EPA Advice on Environmental Impact Statement

Thank you for the request for advice from the Department of Planning, Industry and Environment requesting the review by the NSW Environment Protection Authority (EPA) of the Environmental Impact Statement (EIS) for the proposed Minto Resource Recovery Facility (SSD-5339) at 7 Montore Road, Minto.

Figure 3: Site layout plan.

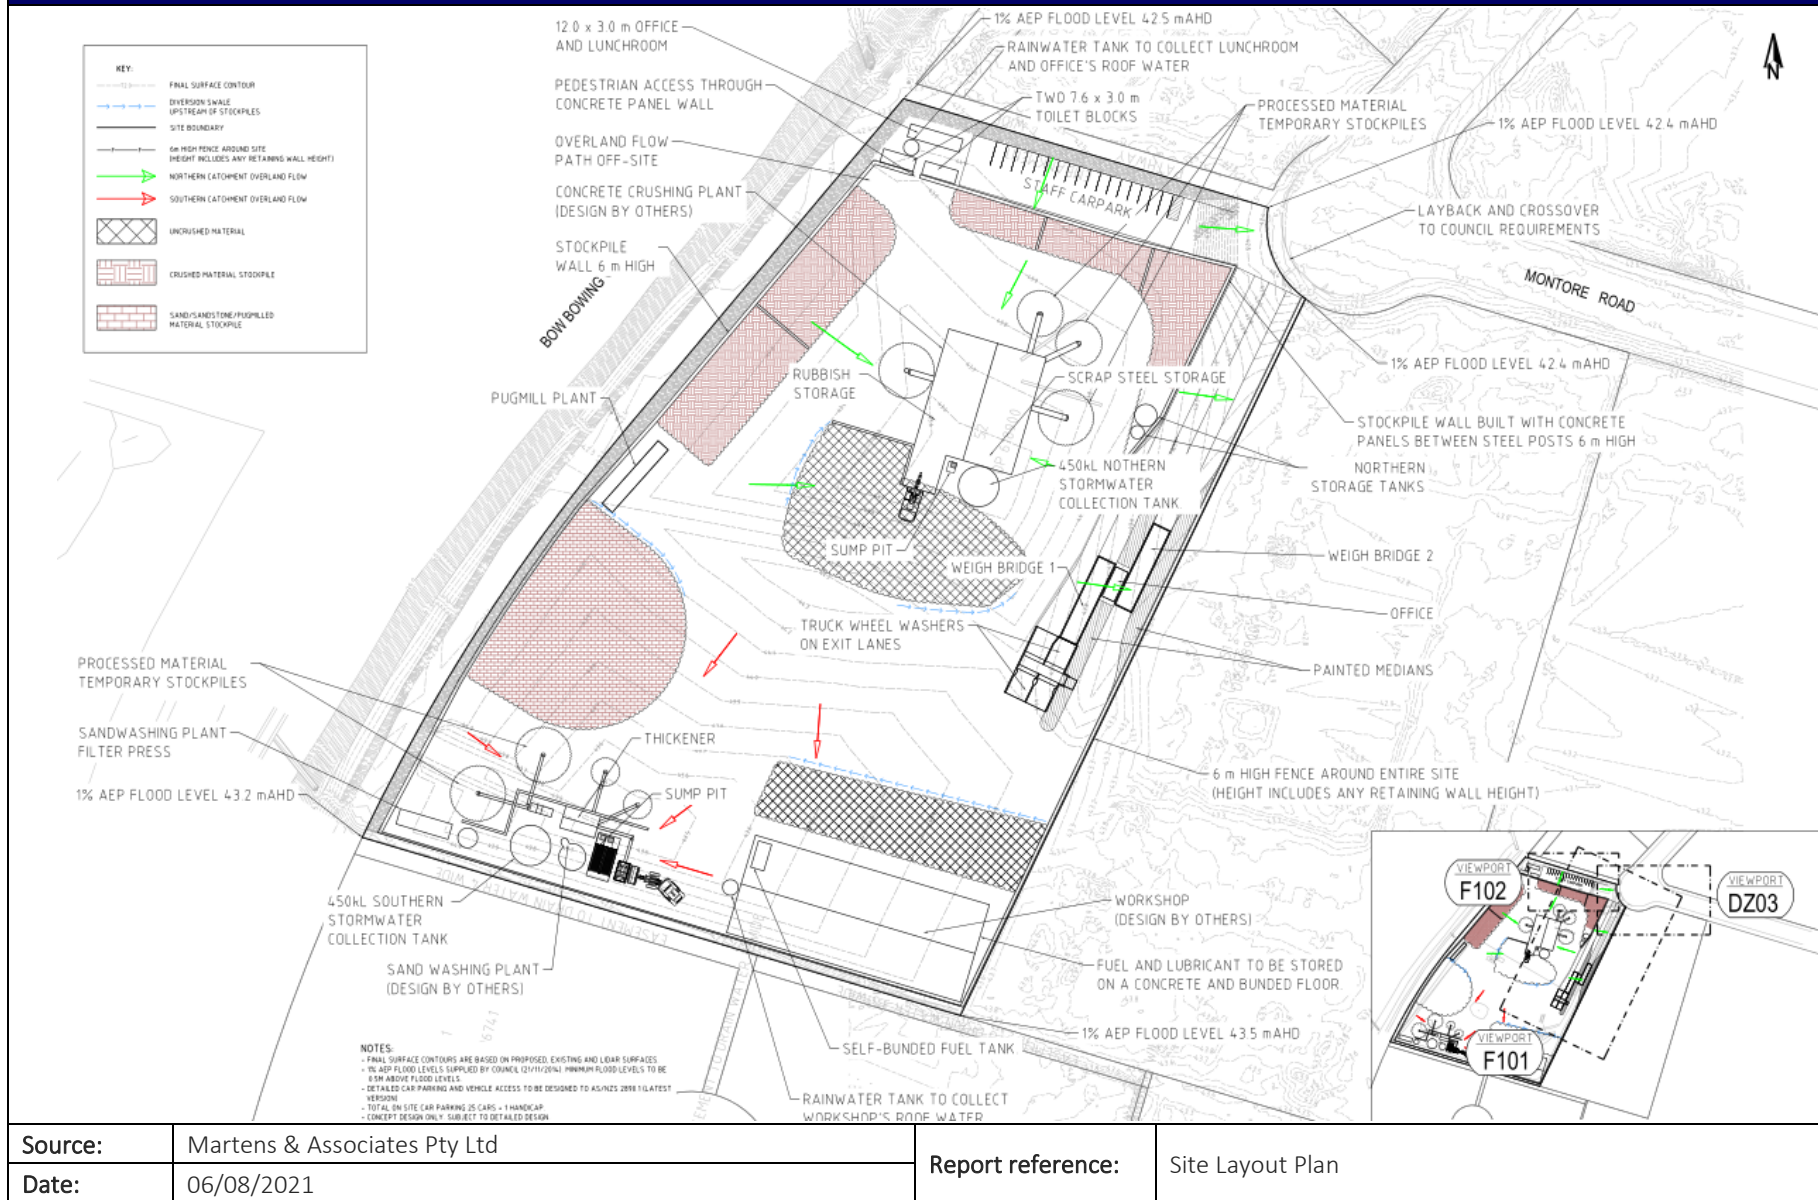
It is also recommended that the applicant identify the quantity of waste to be stored in each dedicated storage area. This should include proposed stockpile layouts, volumes and heights. I note that the site layout plans do not include a dedicated unloading and waste inspection area as required by the EPA's *Standards for Managing Construction Waste in NSW*.

According to the AQIA, the received waste is deposited to a designated stockpile. The site plan shows product stockpiles, but not waste stockpiles (i.e stockpiles of waste prior to processing). It is unclear where on the site the waste stockpiles are located. If waste stockpiles are located outside, they should be included as an additional source.

The proponent should clarify the locations of the waste stockpiles, and whether they have been included as a source of particulate in the modelling. If they have not been included, the proponent should provide justification for not including them, or else revise the modelling to include the additional source.

SECTION 01 - NORTHERN BASIN CONCEPT DESIGN  
NOT TO SCALE

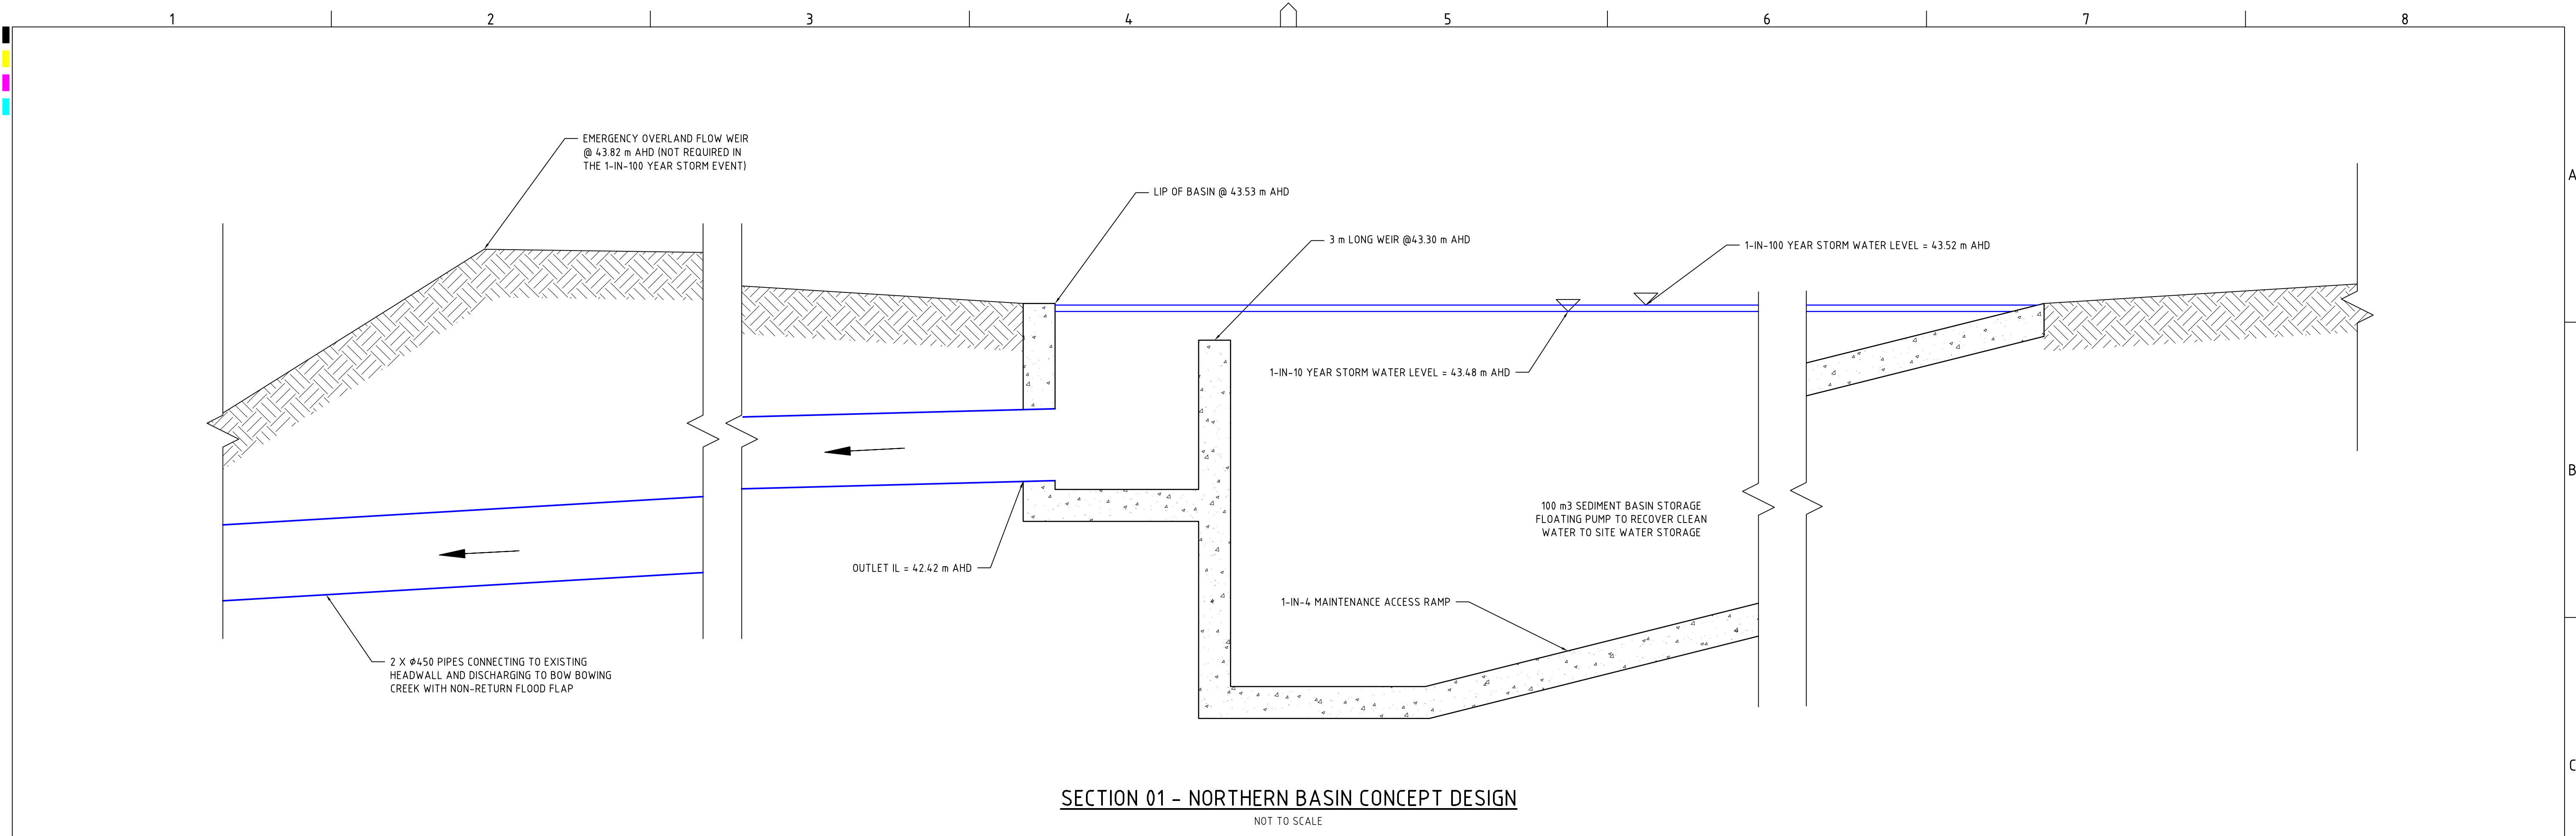
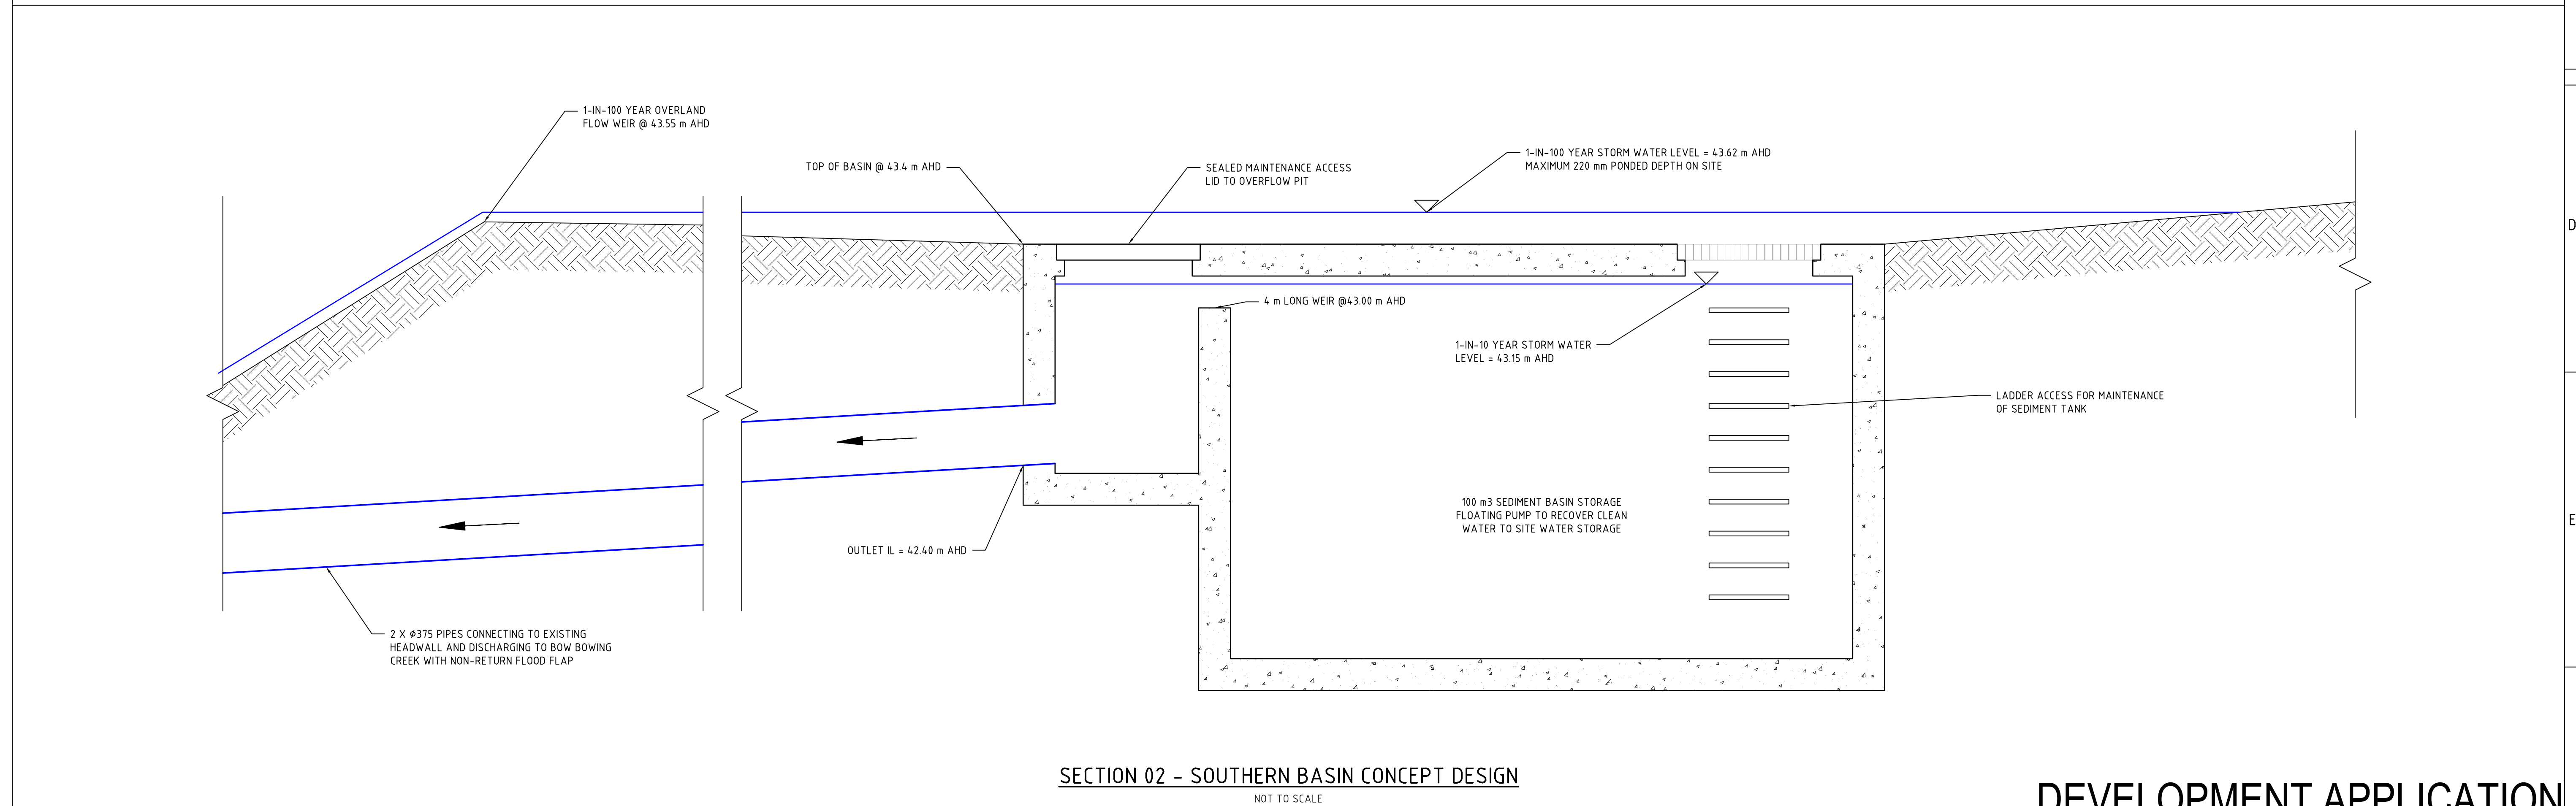
- the location of the southern sediment basin relative to the 1 in 5 year ARI (18% AEP) flood level. Locating the basin above this level will minimise inundation and maximise the basin's effectiveness.
- control of the pumps transferring water from the sediment basins to the storage tanks for reuse. It is unclear if control will be automatic and water will be pumped to the storage tanks from the sediment basins as the storage tanks are drawn down. Automatic control would maximise available sediment basin capacity
